**WEST SUSSEX COUNTY COUNCIL
PLANNING SERVICES CONSULTATION**

FROM: Katie Kurek **TO:** Arun District Council
FAO: S Davis

SUBJECT: P/76/17/PL - 1 No. dwelling adjacent to Manoss Lea & addition of 1 No. window to North elevation & blocking up of 2 No. windows on West elevation to Manoss Lea.

Manoss Lea, 9 Manor Park, Pagham, PO21 3JS

APRIL 2017
DRA 1

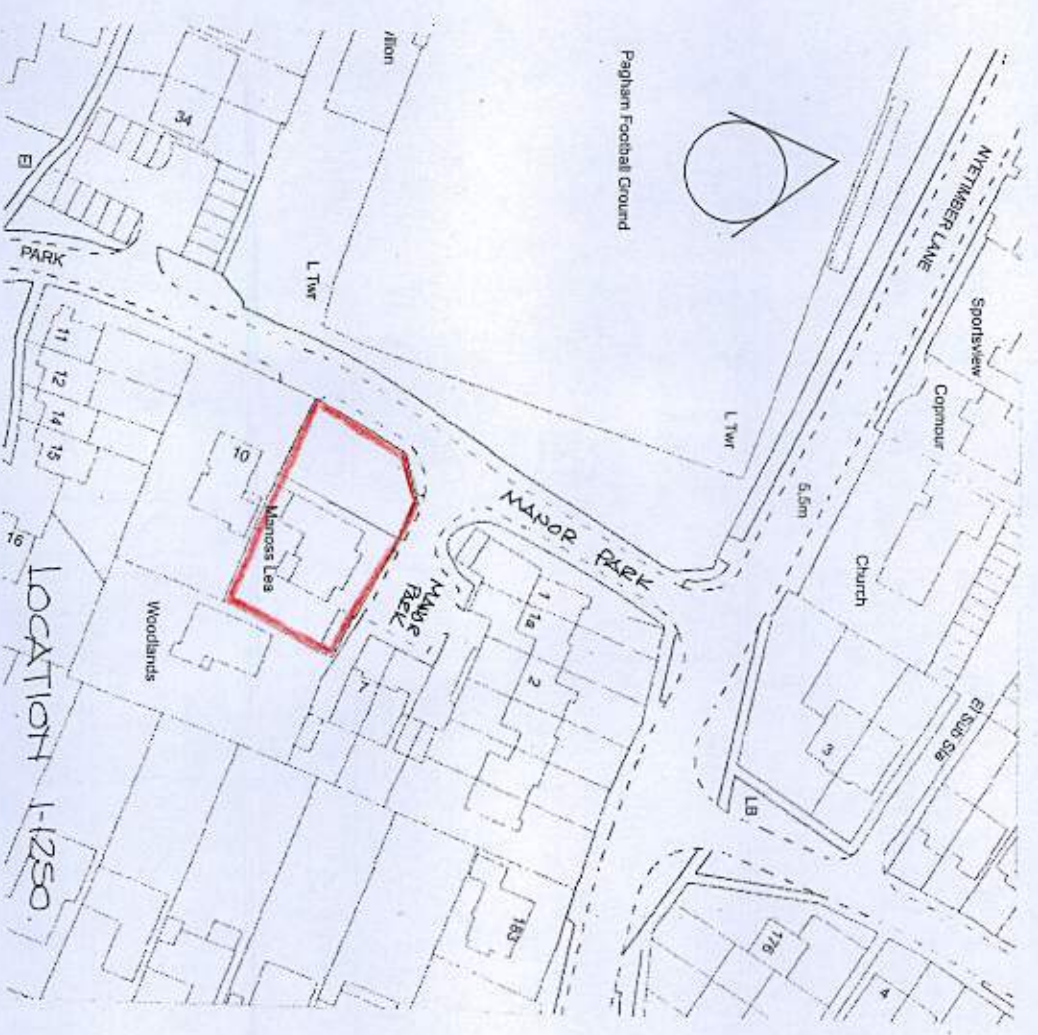
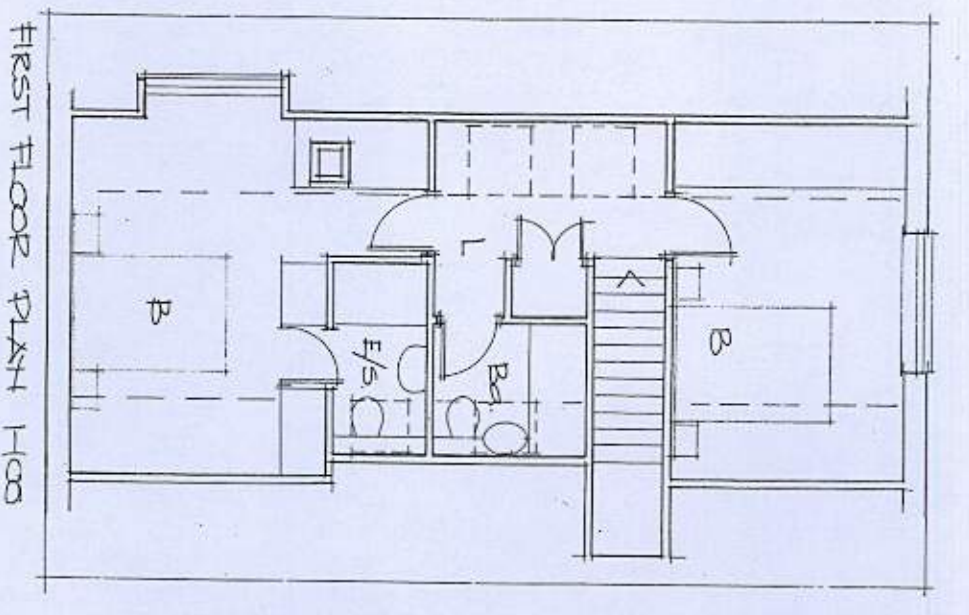
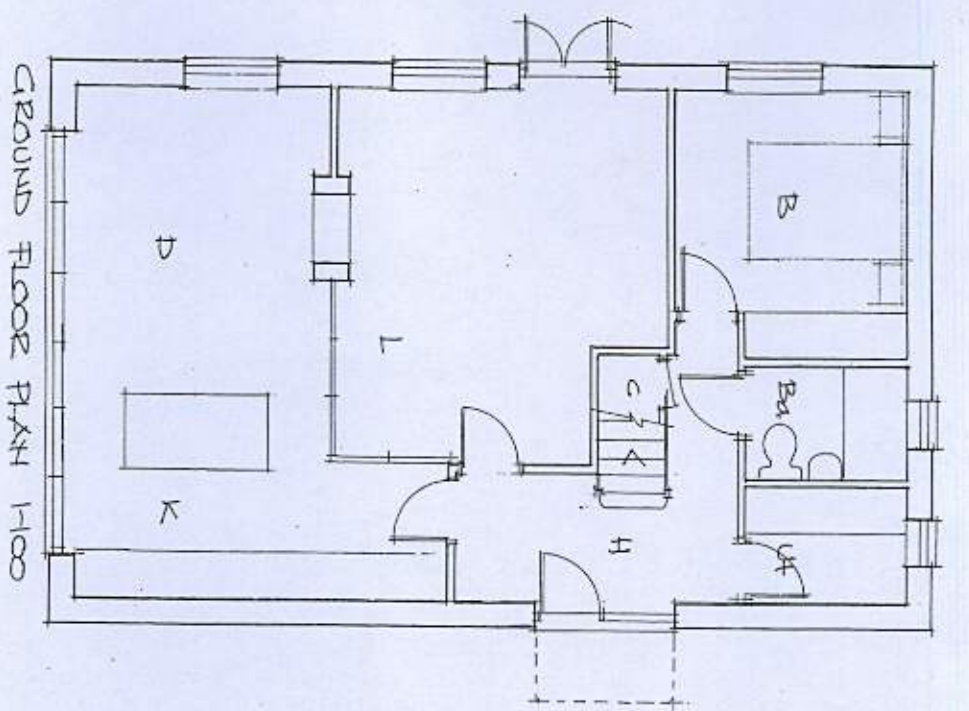
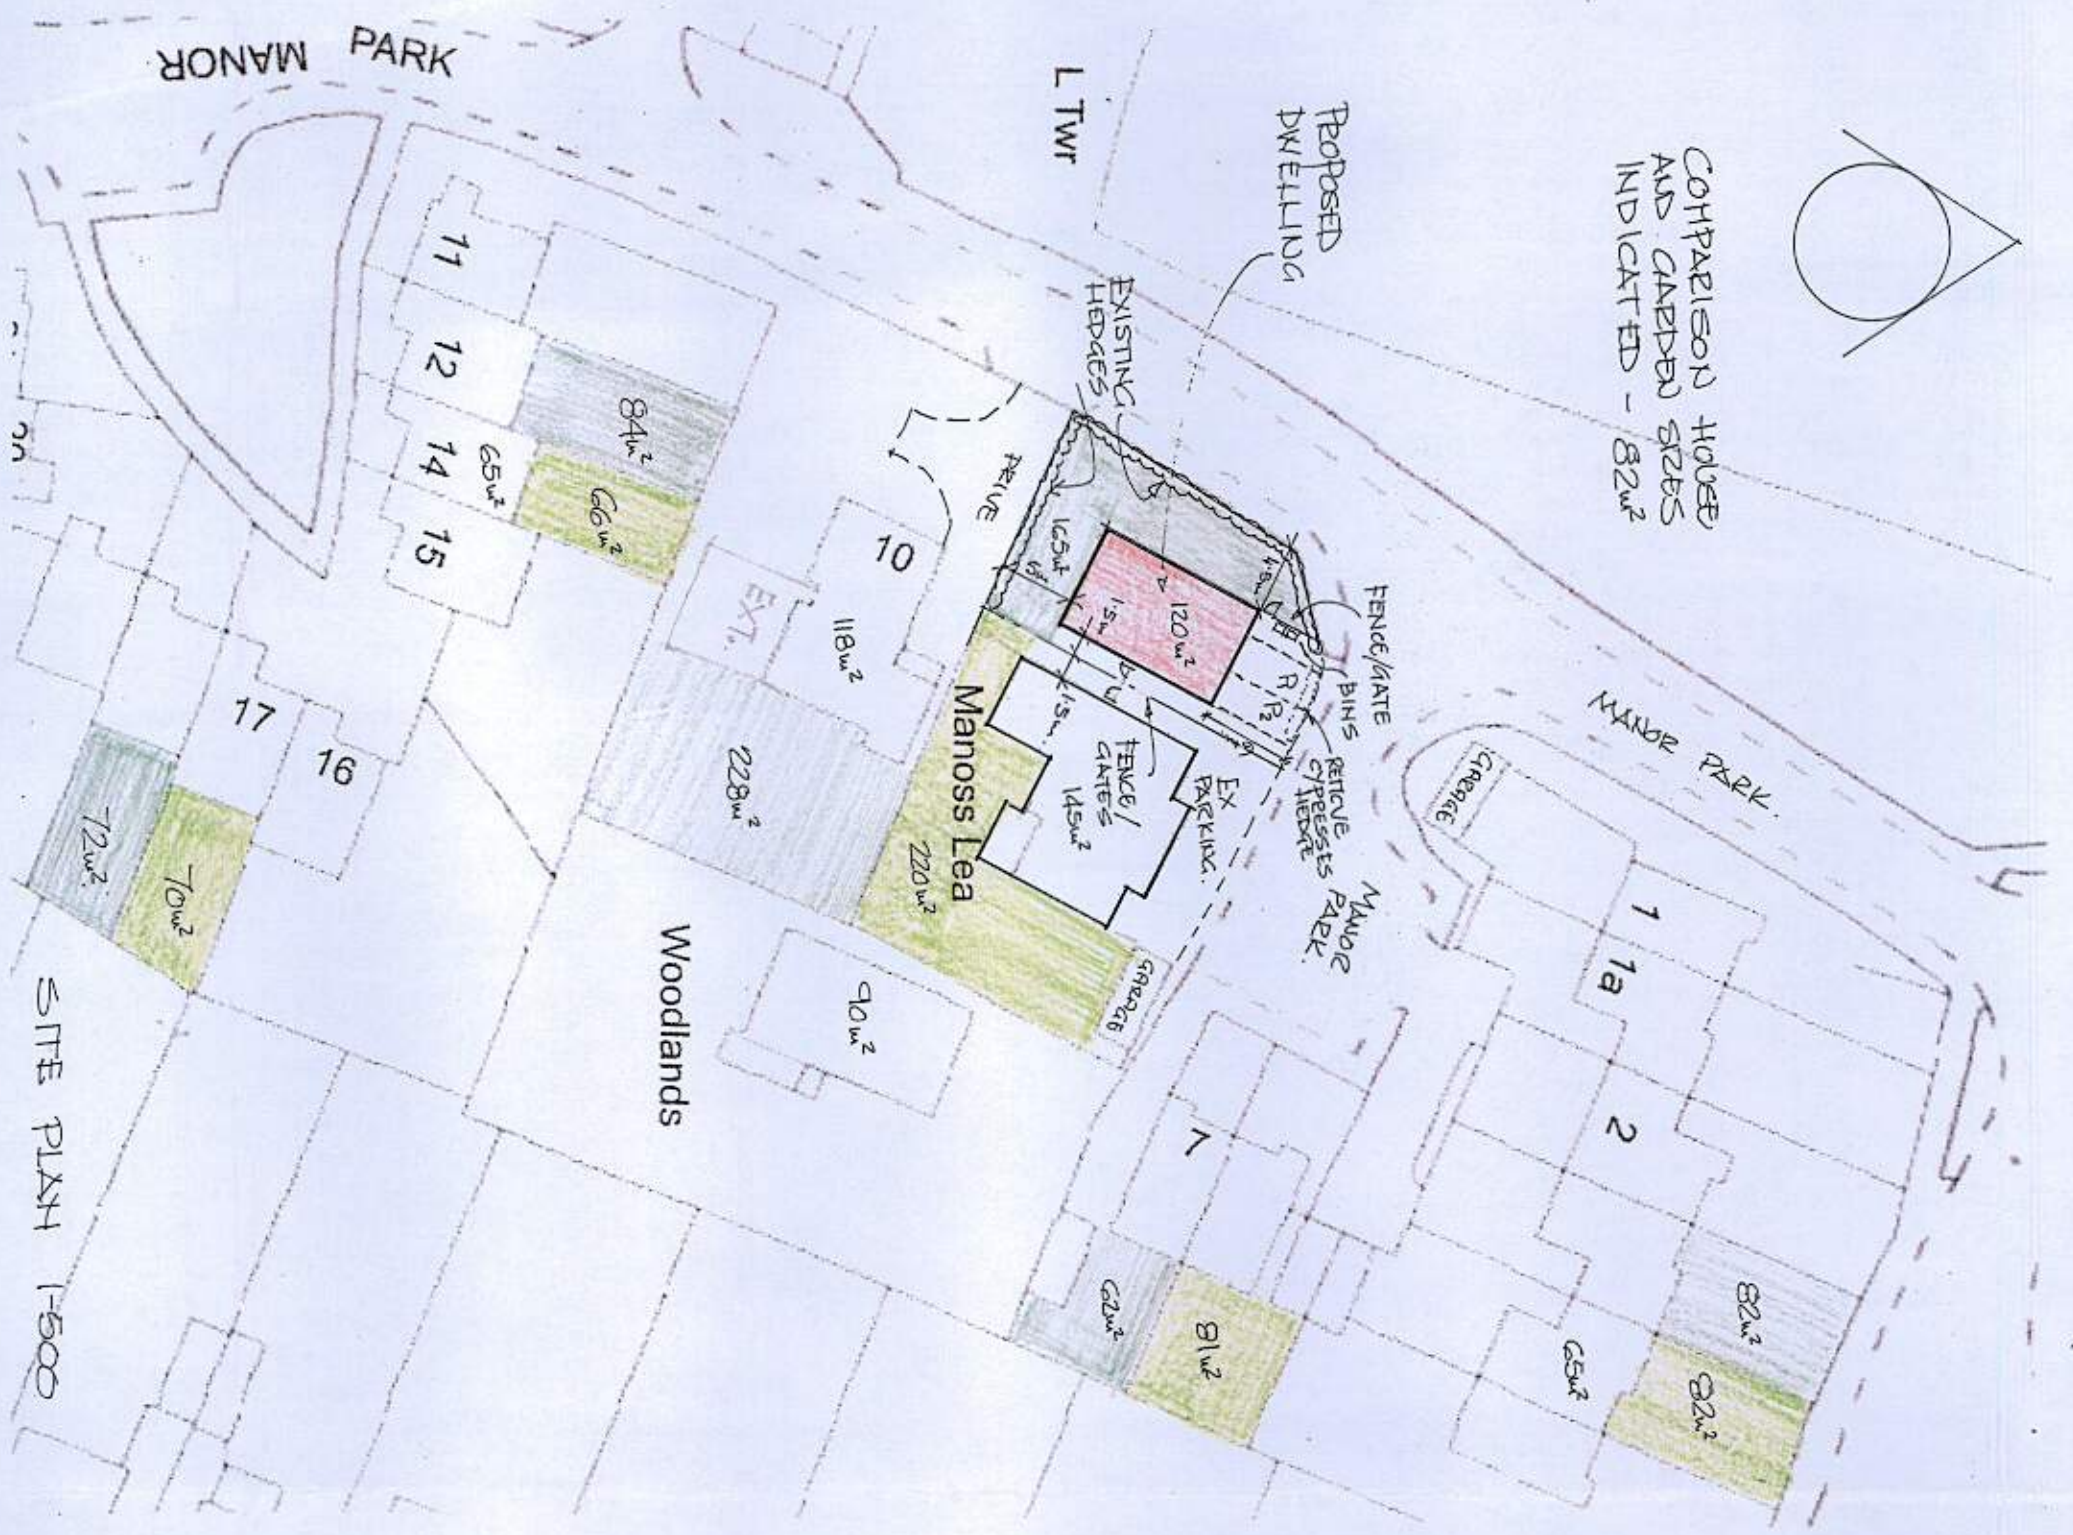
As part of the proposals two off street car parking spaces will serve the new dwelling. This meets with what the WSCC Car Parking Demand Calculator envisions for a development of this scale and location. The existing dropped kerb to the host dwelling will require extending toward the junction in order to facilitate this. The Area Engineer

has been consulted due to the requirement for a new vehicle crossover (VCO) within 10 m of a junction and has advised that the VCO should not be wider than 6.4m due to existing parking pressures and the loss of on-street parking provision for neighbouring residents. It is recommended that the LPA consider the amenity impact of the proposed development should permission be granted. From a highway safety point of view the Local Highway Authority (LHA) does not raise a concern to the proposed VCO access and parking arrangements. Whilst no turn on site is available neighbouring properties have a similar arrangement without evidence of highway safety concern.

Secure and covered bicycle storage will be included to the side of the dwelling. Details of this can be secured via condition.

No part of the development shall be first occupied until the car parking has been constructed in accordance with the approved site plan. These spaces shall thereafter be retained at all times for their designated purpose.

No part of the development shall be first occupied until covered and secure cycle parking spaces have been provided in accordance with plans and details submitted to and approved by the Local Planning Authority.
